**From:** [Robert Stark](#)  
**To:** [Simon Truong](#)  
**Cc:** [Amy Watson](#); [JustinClark@grocon.com.au](mailto:JustinClark@grocon.com.au); [chriscarolan@grocon.com.au](mailto:chriscarolan@grocon.com.au)  
**Subject:** RE: IMAX  
**Date:** Wednesday, 4 May 2016 10:20:41 AM  
**Attachments:** [image002.png](#)  
[image003.png](#)  
[image004.png](#)  
[image005.png](#)  
[004409\\_HASSELL\\_The\\_Ribbon\\_Hotel\\_Serviced\\_Apartments\\_and\\_Retail\\_Pedestria....pdf](#)  
[Management Plan for Ribbon Hotel - V3.pdf](#)

**From:** [Simon.Truong@planning.nsw.gov.au](mailto:Simon.Truong@planning.nsw.gov.au) [mailto:[Simon.Truong@planning.nsw.gov.au](mailto:Simon.Truong@planning.nsw.gov.au)]  
**Sent:** Tuesday, 3 May 2016 2:31 PM  
**To:** Robert Stark  
**Cc:** [Amy.Watson@planning.nsw.gov.au](mailto:Amy.Watson@planning.nsw.gov.au)  
**Subject:** RE: IMAX

As discussed, following review of the additional information submitted, the Department requires the following:

**GROUND FLOOR:
BUILDING FOOTPRINT COMPARISON**

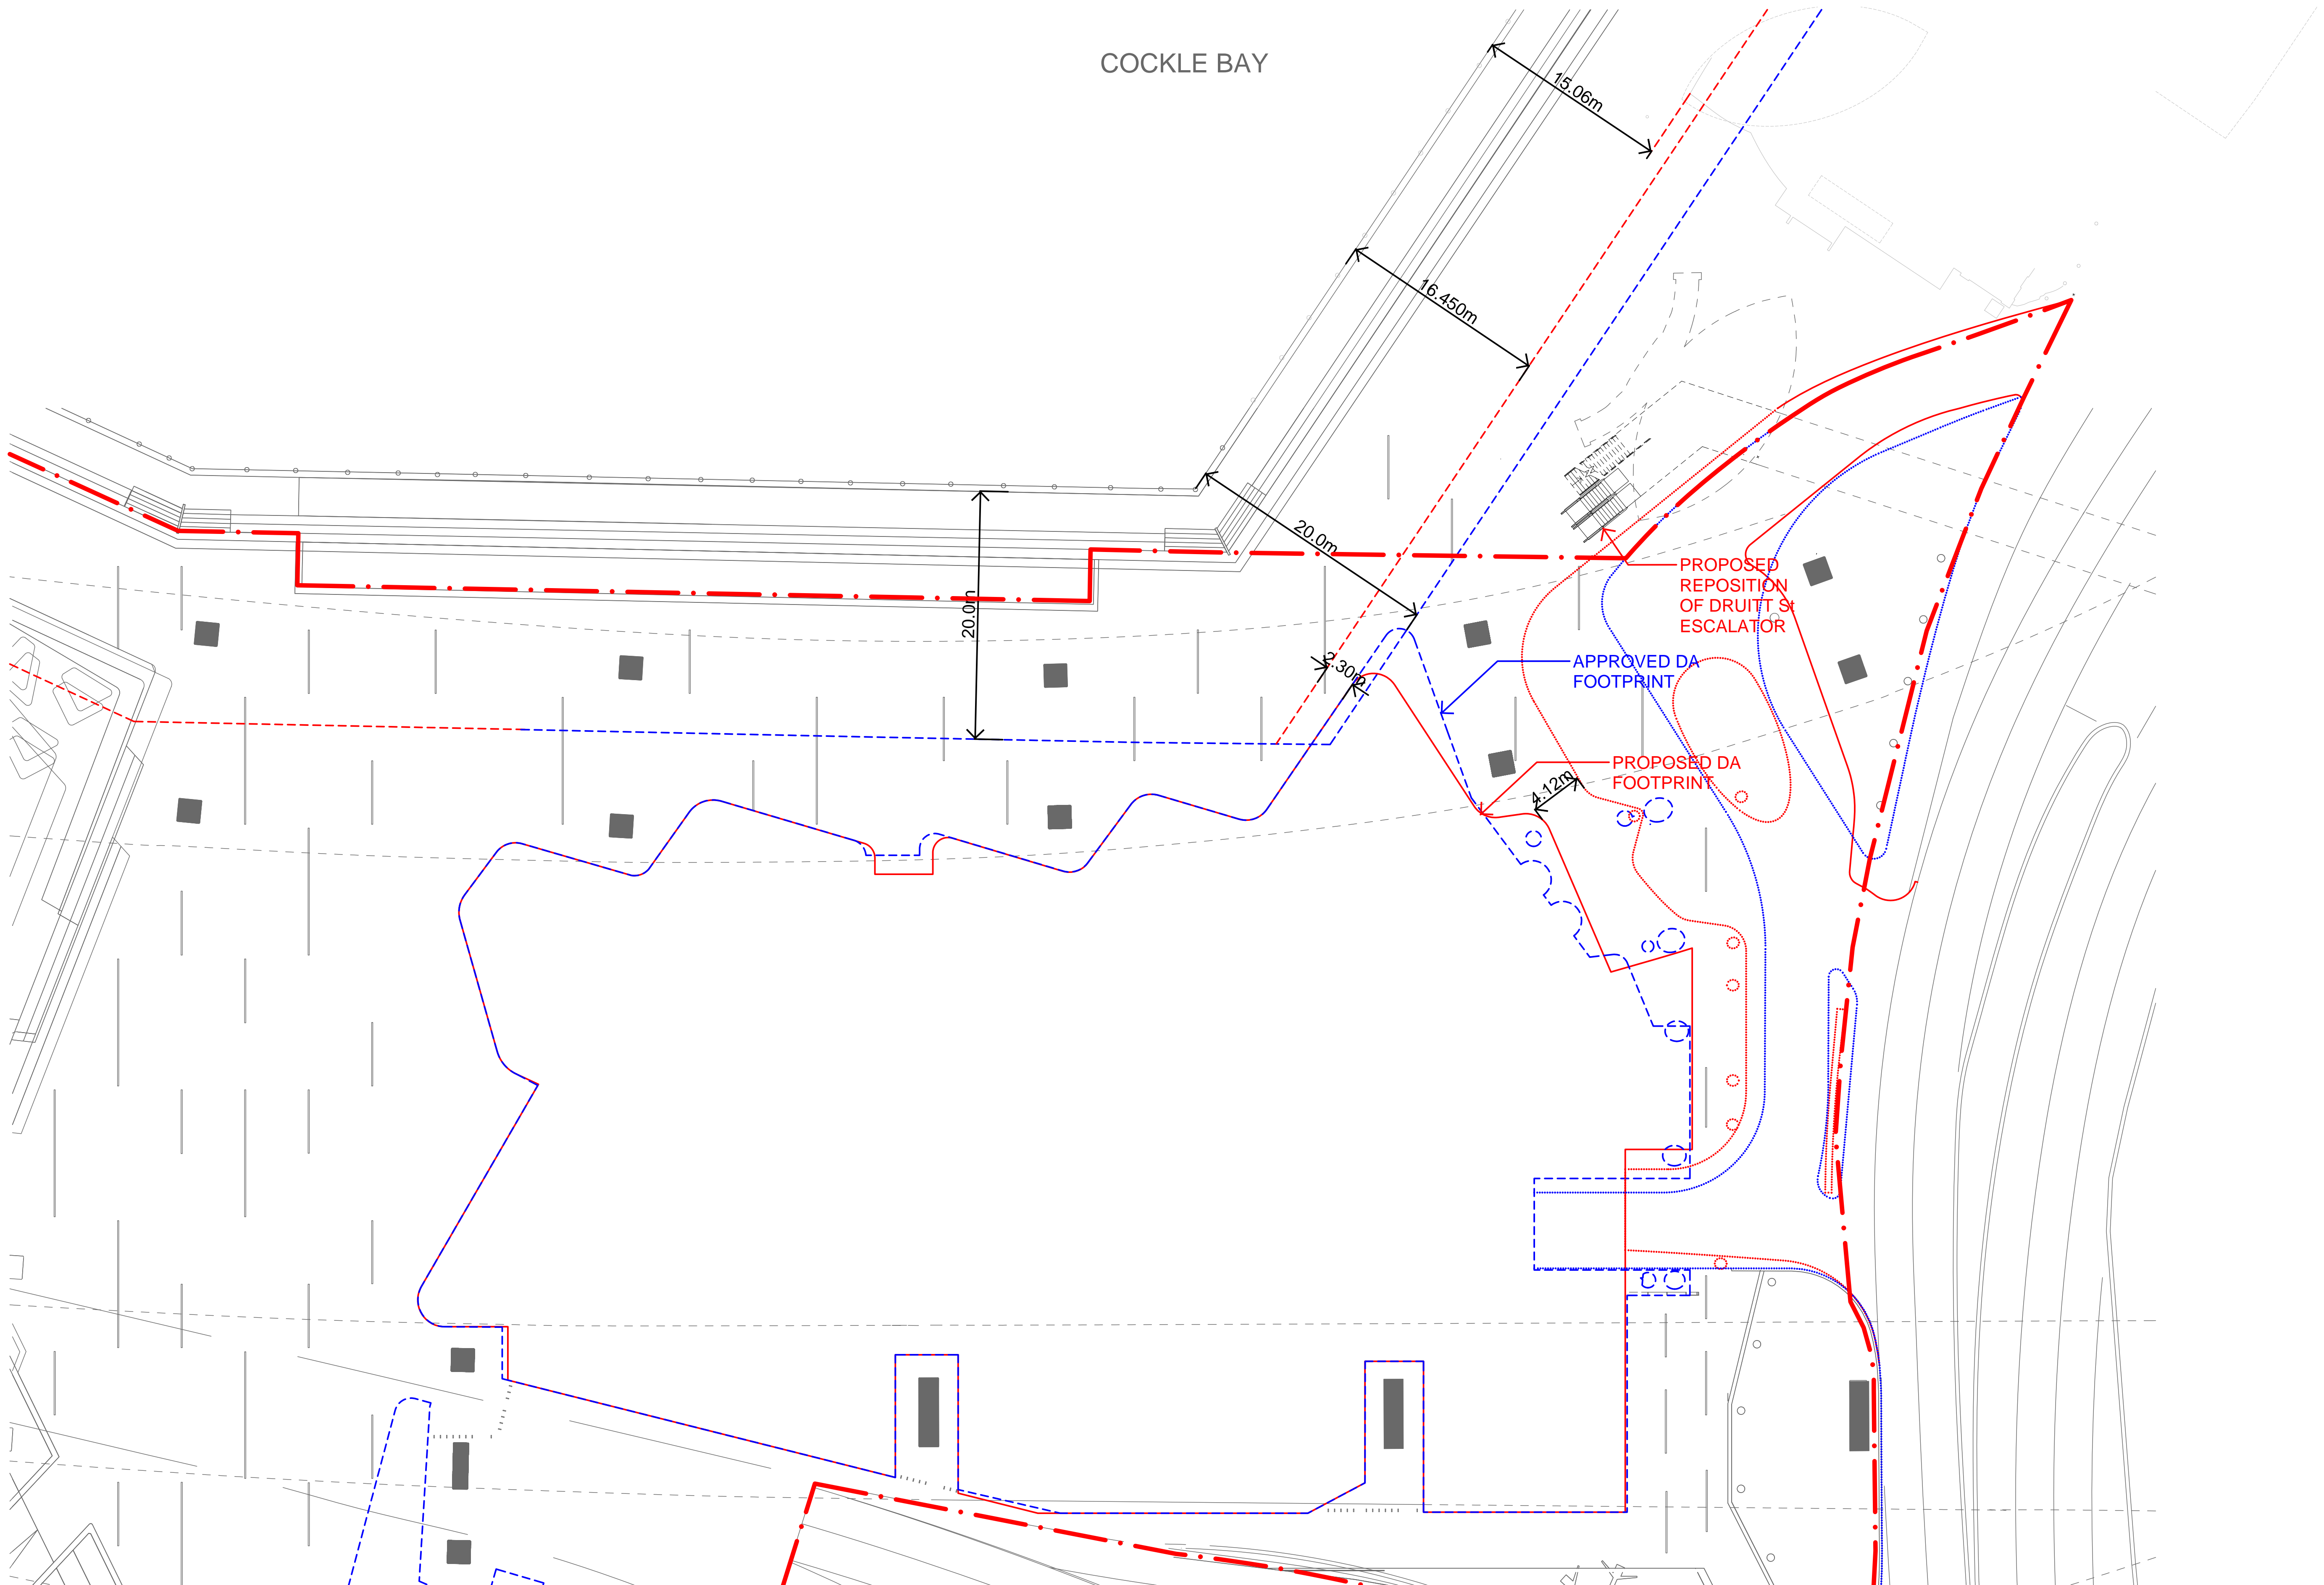
- further justification as to why the proposed two storey foot print for the SHFA building is unable to be realigned with the existing footprint as per the PAC's requirement with the commercial scheme (condition B3);
  - The external outline and internal dimensions proposed for the SHFA building were developed in collaboration with SHFA to create tenancies and a public domain that can attract appropriate and viable tenants, and meaningfully activate the pedestrian pathway. It is important to note that the structure of the roadway above is a significant constraint, providing obstruction in height as well as depth. It is not possible to simply 'push' the SHFA building deeper under the roadway.
    - o Activation of the Public Domain – The alignment and detailing of the SHFA Building have been developed to form a continuous and activated edge to the public domain.

- confirmation on how the proposed pedestrian width in this location compares with both:
  - the pedestrian width that would be provided in satisfying condition B3 of the previous approval;

- the current pedestrian width in this location between the existing amenities building and the carousel;
- Existing walkway width – Min 13.0 metres (to top of steps)

The curved west-facing façade relates to the alignment and profile of the IMAX and retail facades of the main Ribbon building. These facades are all accessible on-grade from the level of the public domain.

- Walkway width if the commercial scheme is modified as per condition B3 – 14.4 metres
- Current proposed width – 12.25 metres

Note – These are minimum pinch-point dimensions. Adjacent to the new carousel and further north, the walkway width is substantially wider than the existing condition. – Please also see attached diagram.
